Recommendation: Approve

Applicant: Albion Land

Proposal: Non-material amendment to 22/01632/REM - vary 12 of the approved plans and drawings listed in Conditions 1, 2 and 3. Amendments to Units 8 and 9 into a single unit, along with minor changes to Units 6, 7, and 8.

6.1. The proposal is considered to be non-material and the application is therefore recommended for approval.

Drawing Title:  
**UNIT 8 ELEVATIONS**

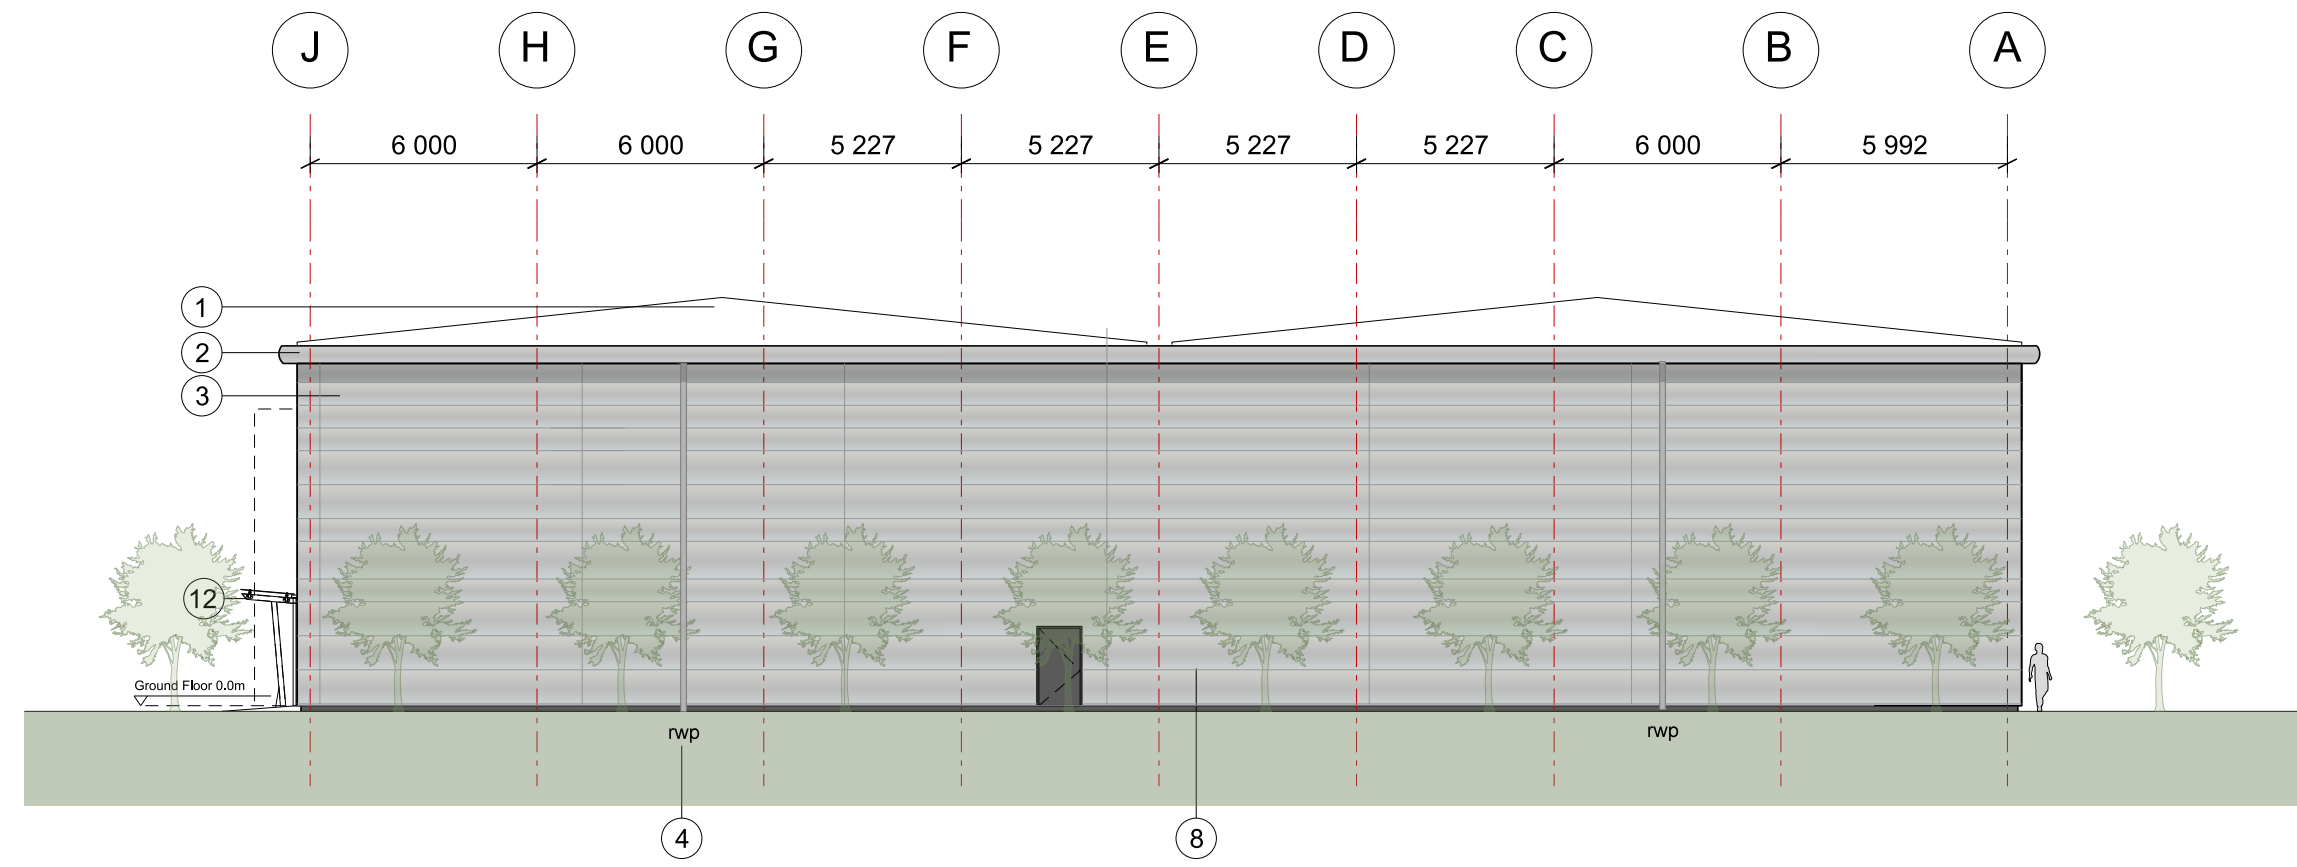
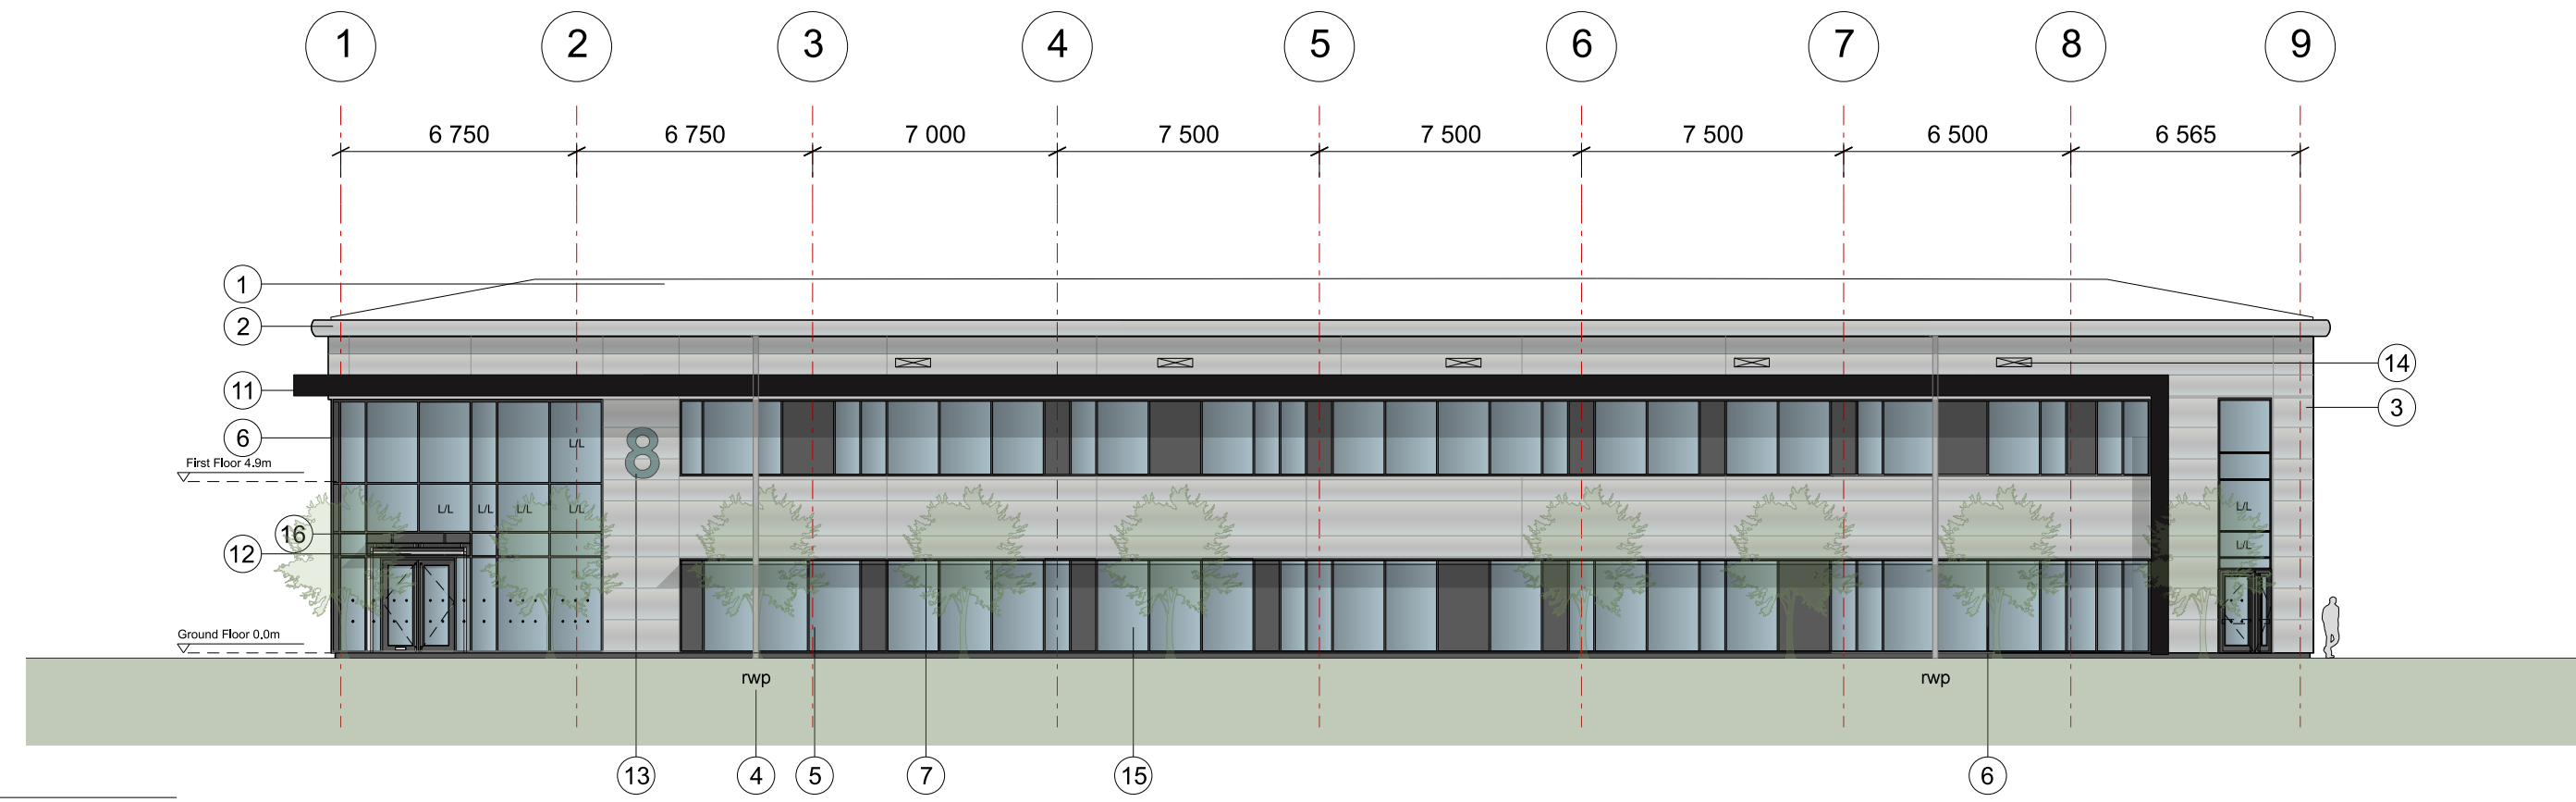
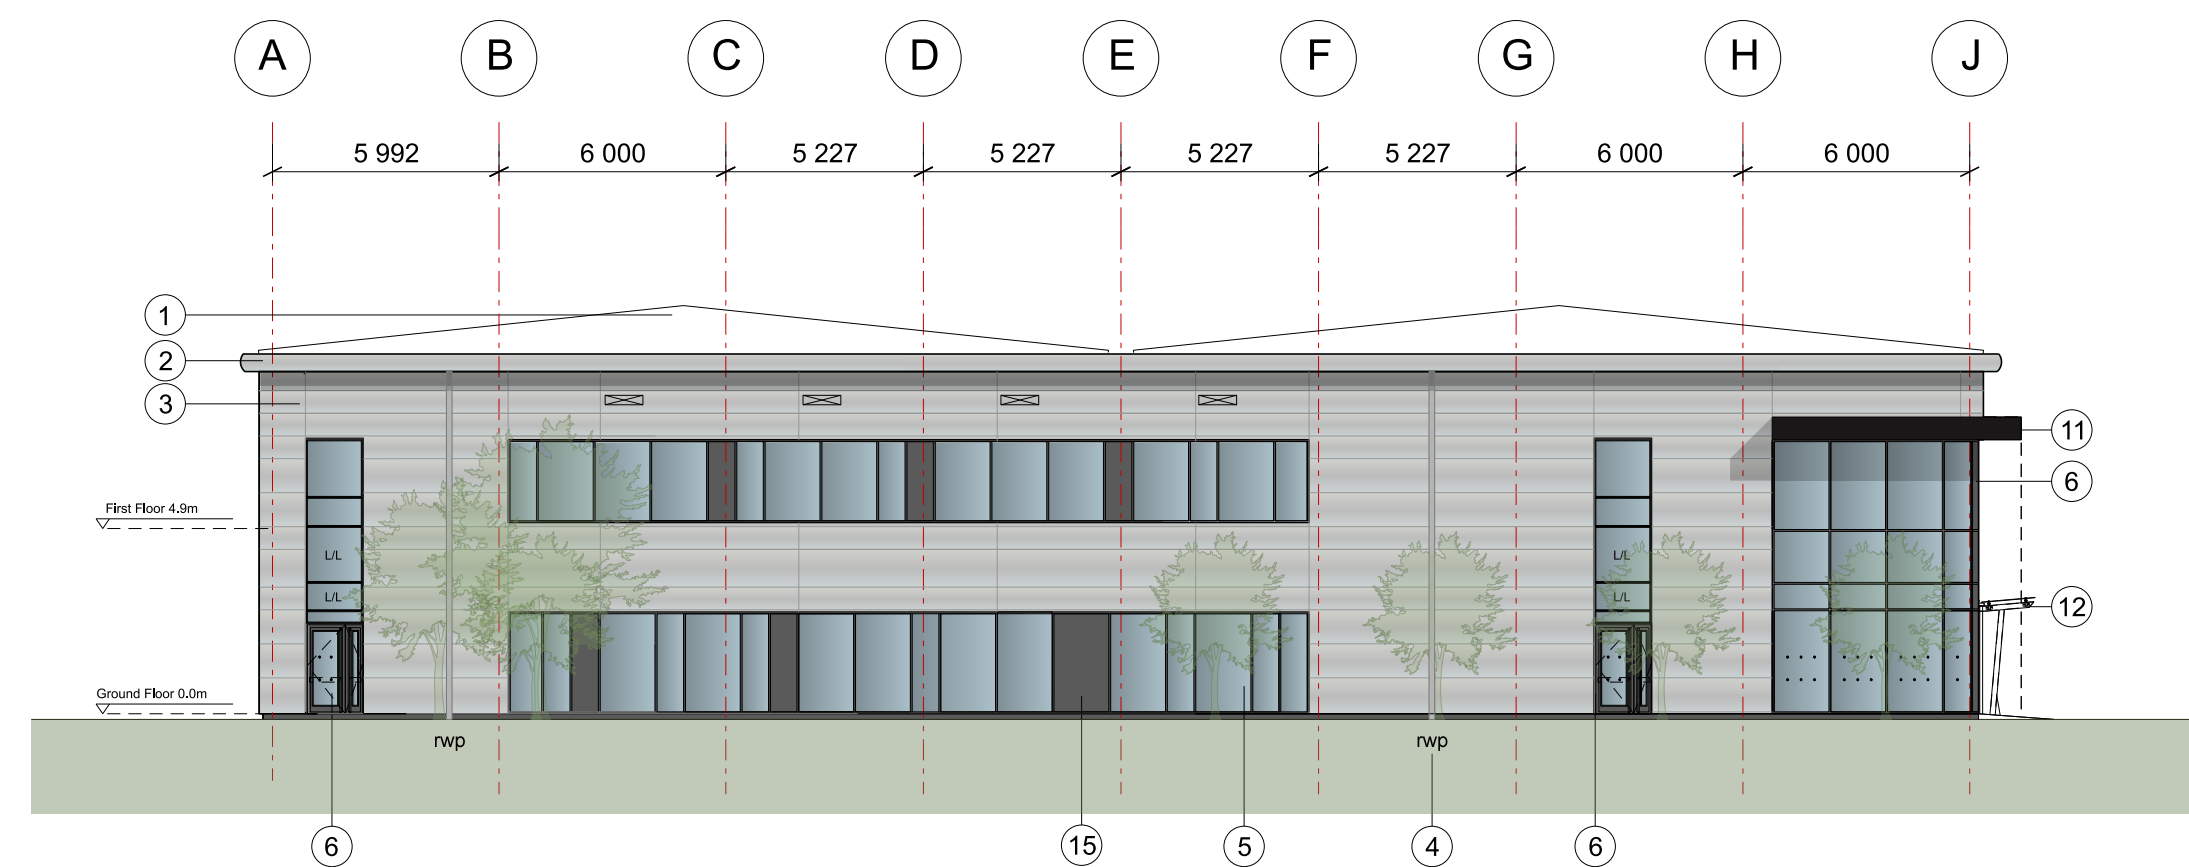
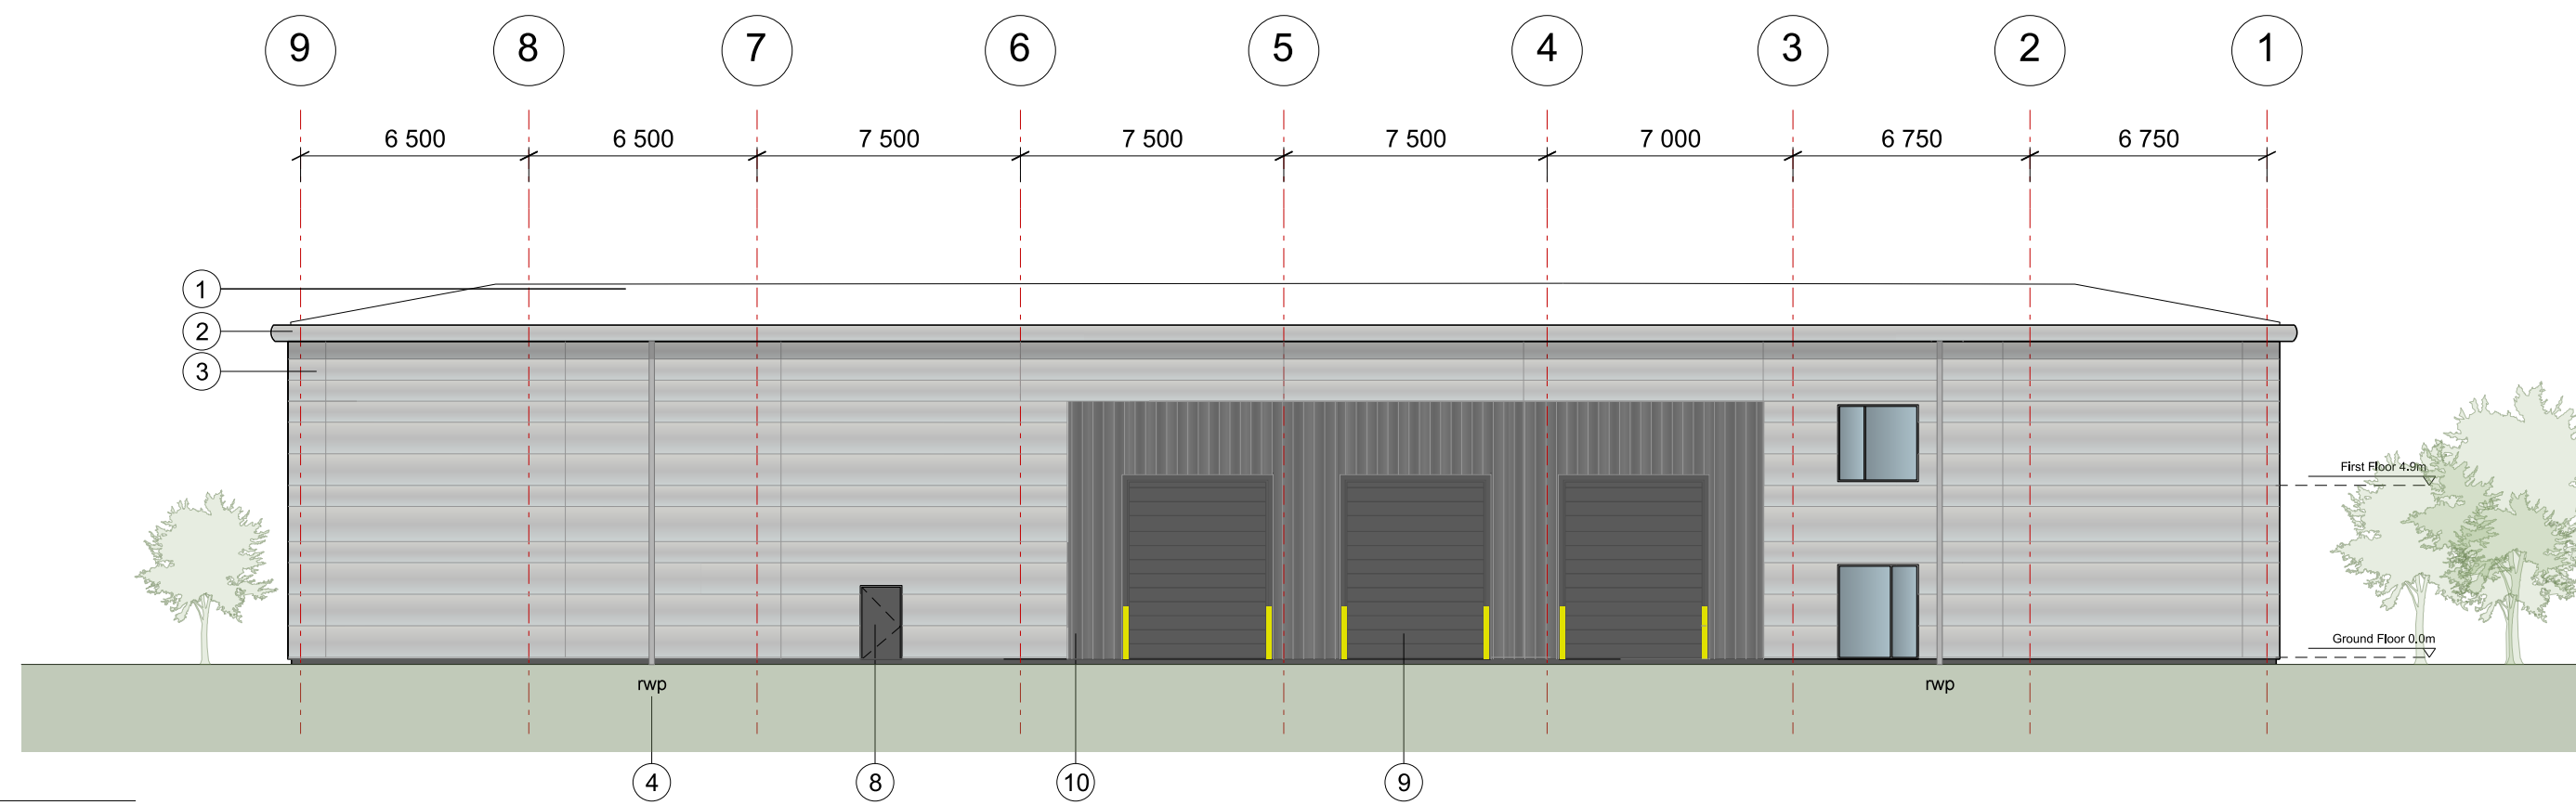
Changes have been made to the layout of car parking, cycle storage location and bin stores and EV charging spaces, to reflect the merging of Units 8 and 9 to Unit 8. The changes do not alter the overall number of parking or cycle spaces. The changes are being sought by varying conditions 1, 2 and 3 of the aforementioned reserved matters. Greater changes are proposed to the elevational design of unit 8 to reflect it as one unit rather than 2 (8 and 9 previously) – these changes are considered to be acceptable as they remain complementary to the design of the overall park and the design on some elevations as proposed now is elevated beyond that previously approved.
